## Comments on the Applicant's D5 submissions

This document sets out the comments on the Applicant's Deadline 5 (D5) submissions by Cambridgeshire County Council (**CCC**), Huntingdonshire District Council (**HDC**) and South Cambridgeshire District Council (**SCDC**) (together, the **Councils**). The tables below set out the document in question that the Councils are commenting on, together with the relevant paragraph or reference number.

### 9.54 Barbastelle Bat Surveys and Mitigation Technical Note (Rev 2) [REP5-006]

Filename: W:\Active Projects\A428\GIS\02\_Maps\A428\_GCNI\A428\_GCNI\_C3-2a\_Survey.mxd

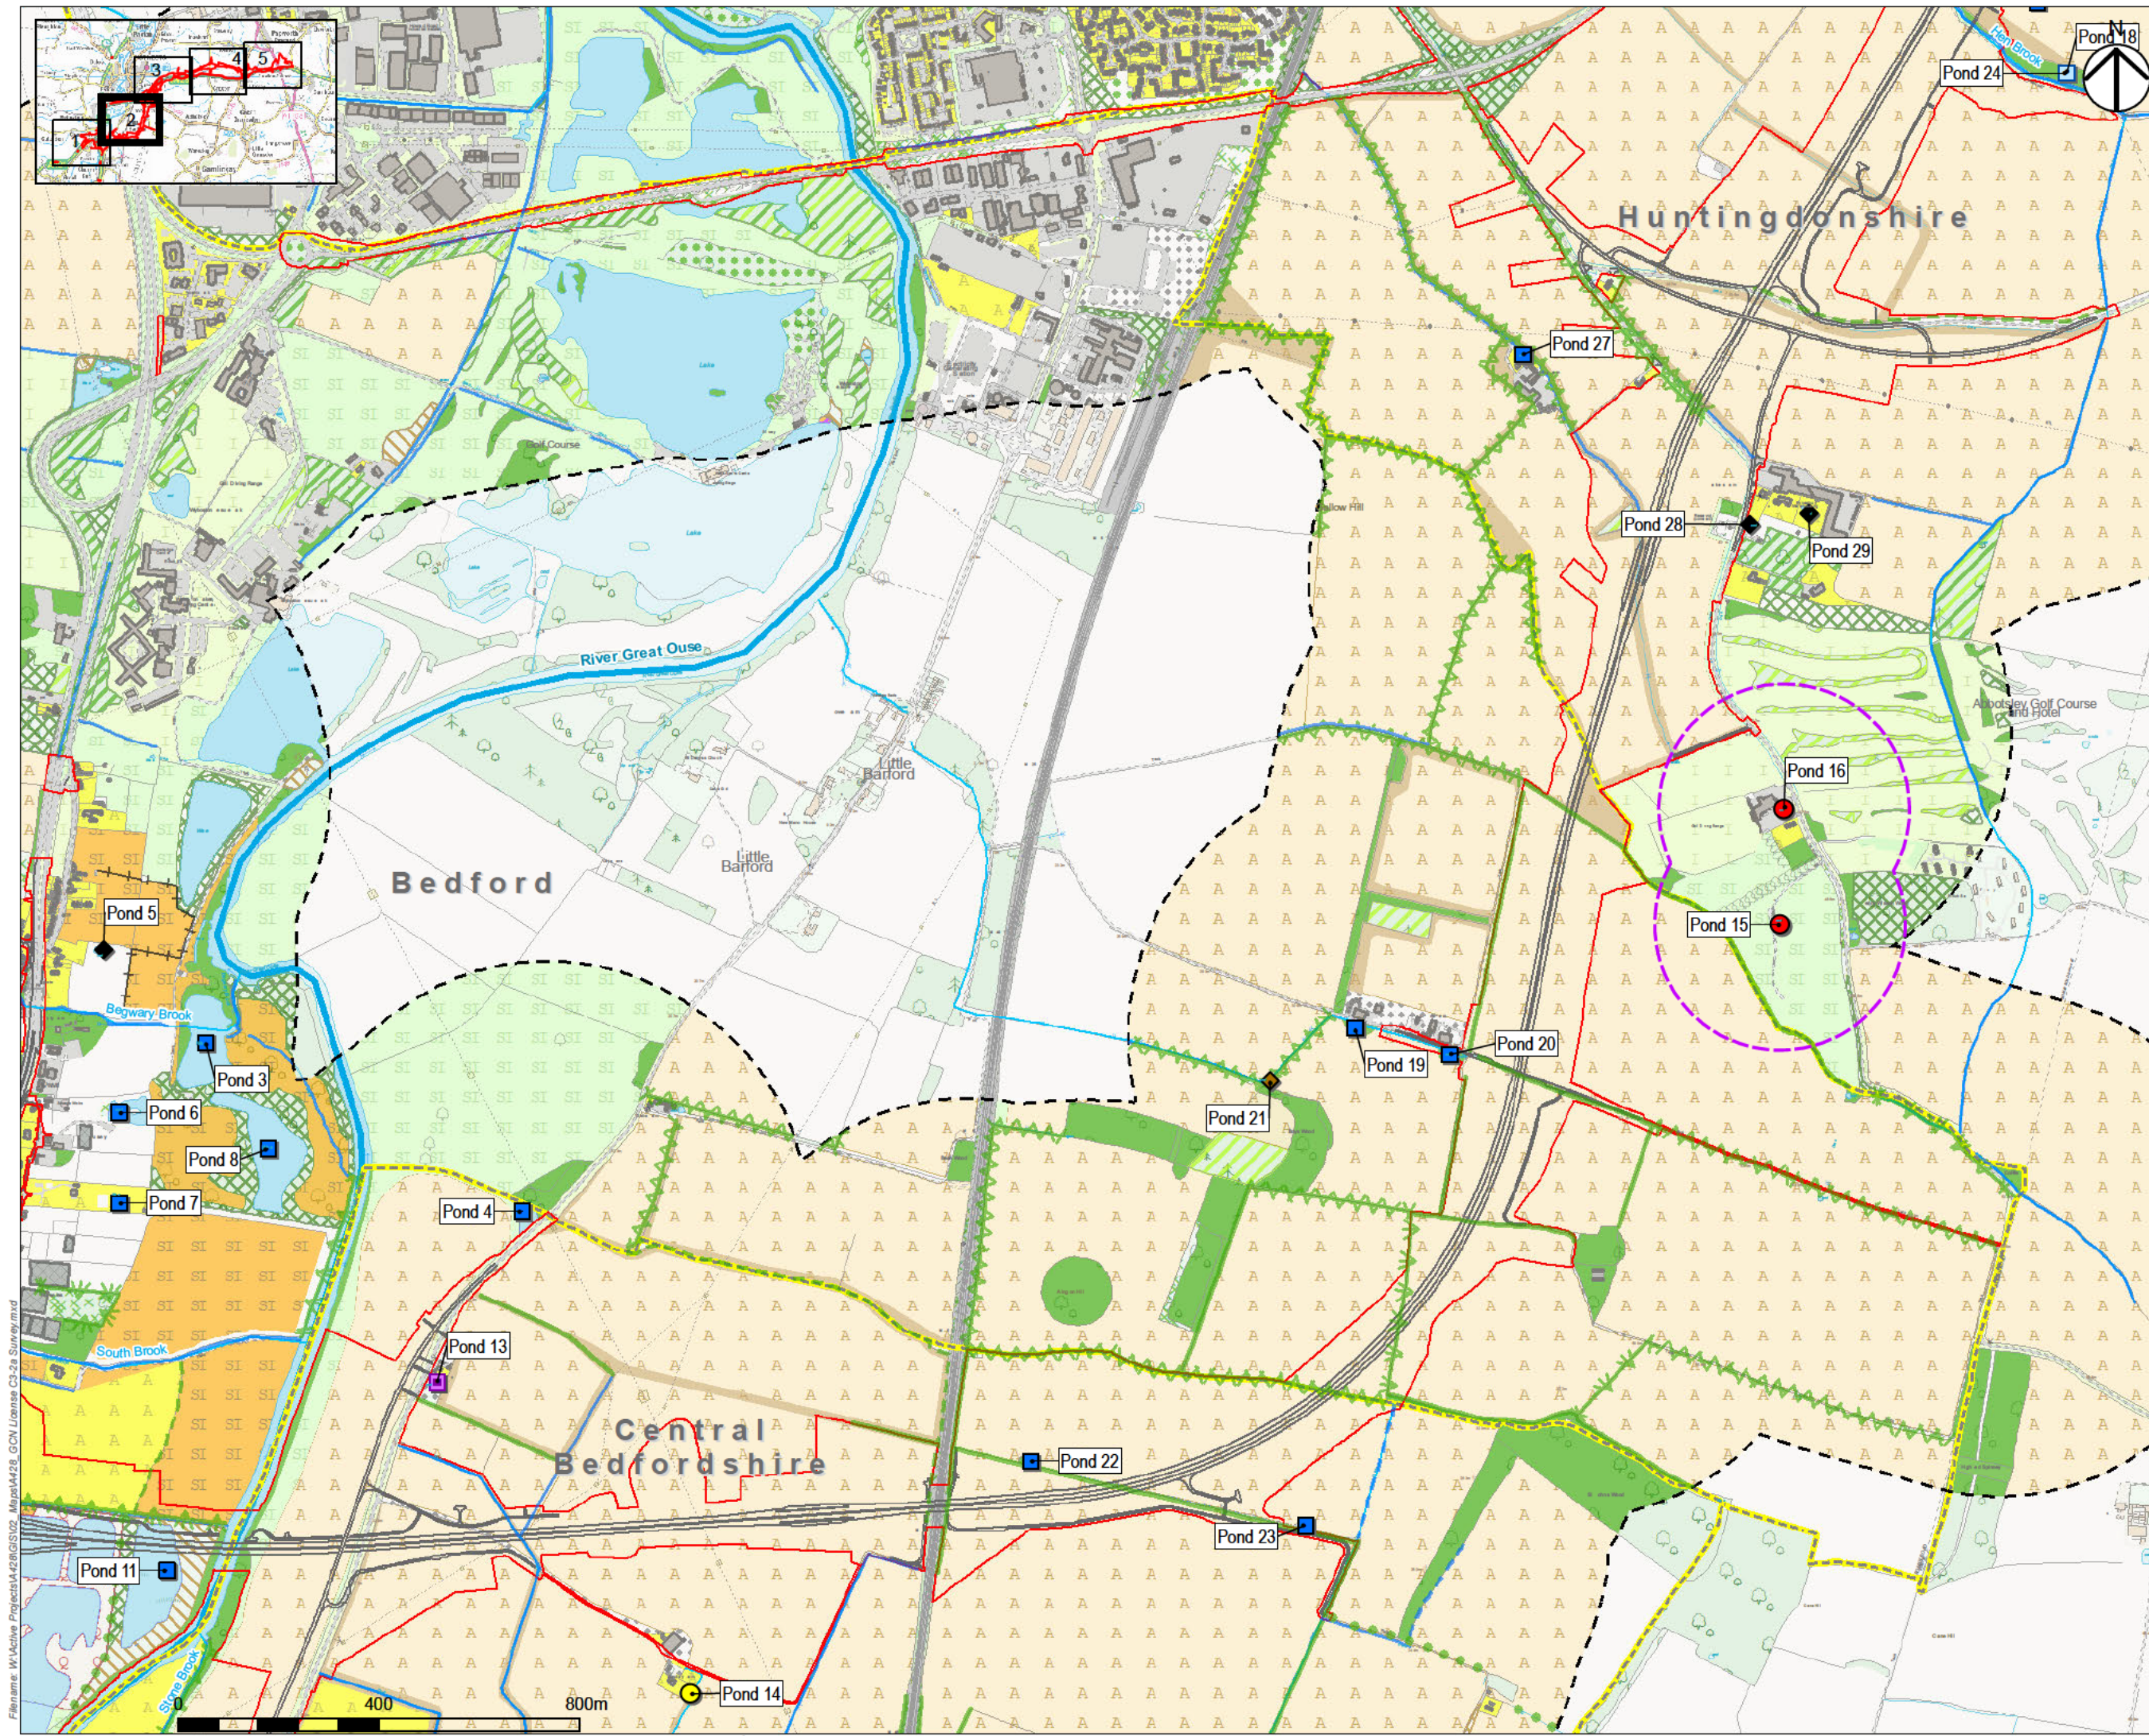
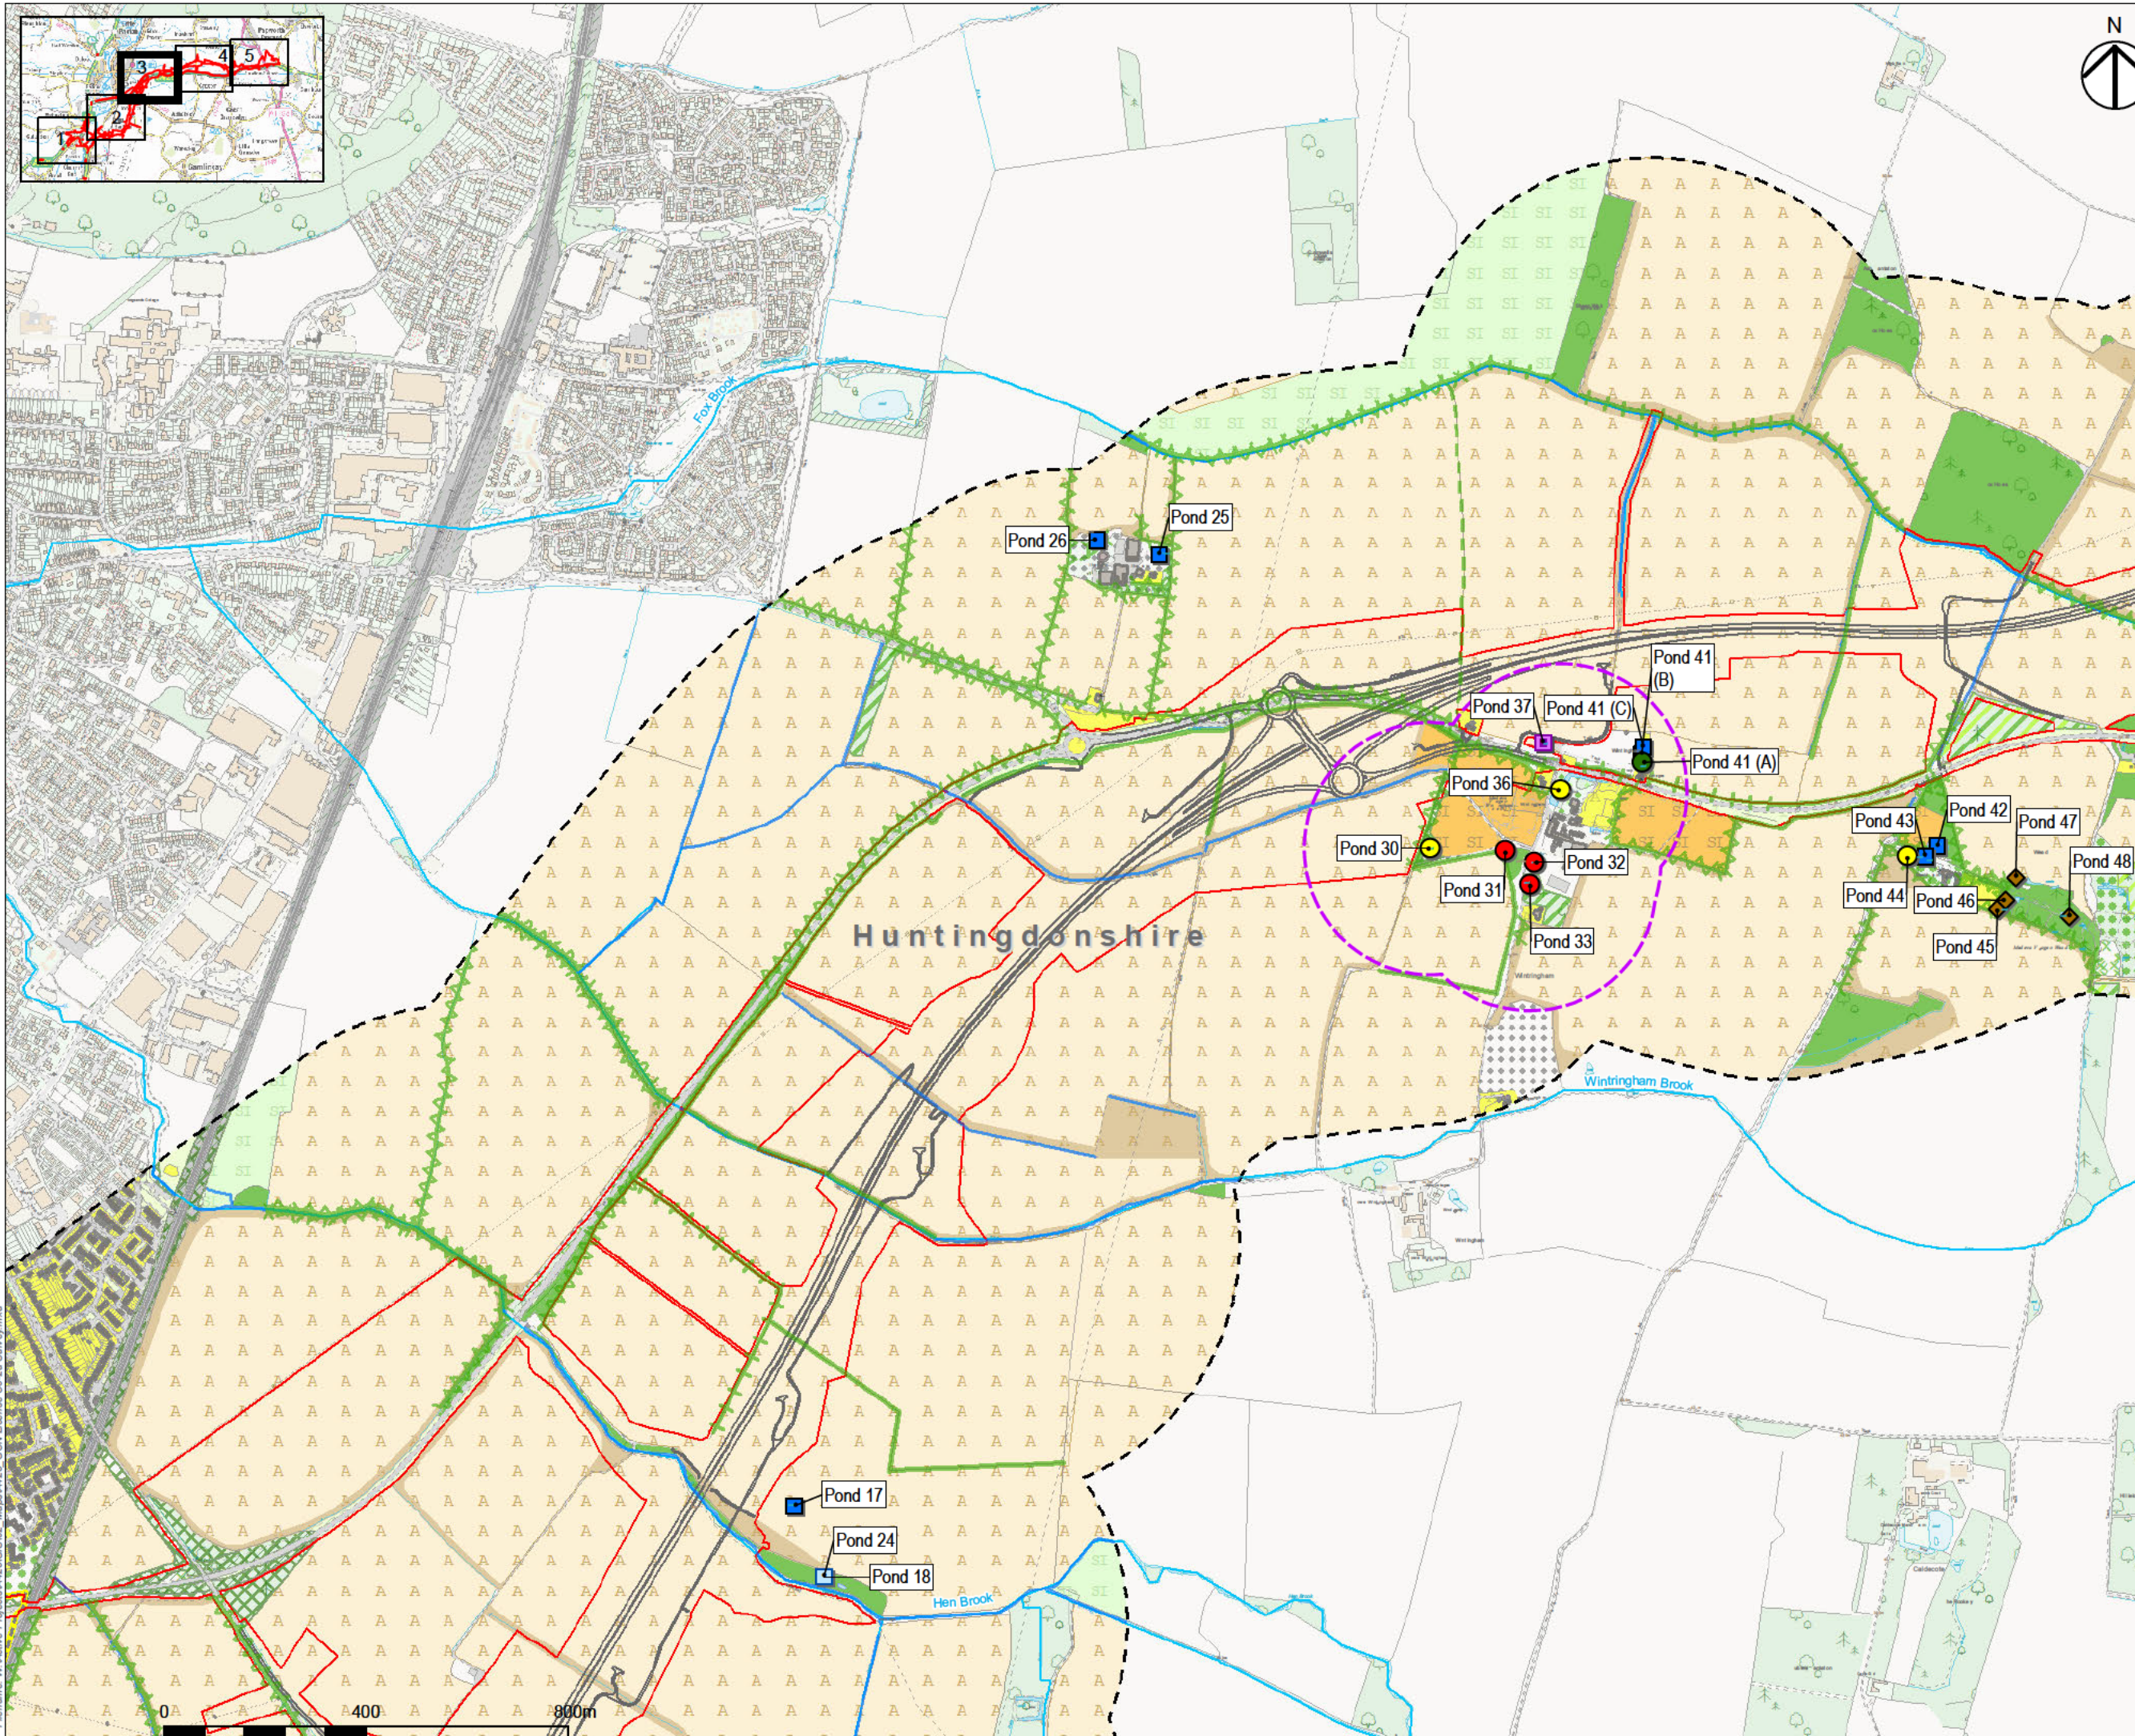
Pond 84	7.3.1	<p>Pond 84 is one of two ponds that will be lost in Cambridgeshire as a result of the proposed development.</p> <p>Pond 84 was found to be dry in 2021. We support National Highways conclusion that the pond is unlikely to support any regular breeding by Great Crested Newts. Therefore, this addresses our previous concern with regards to the loss of this ponds for GCNs.</p>
---------	-------	---
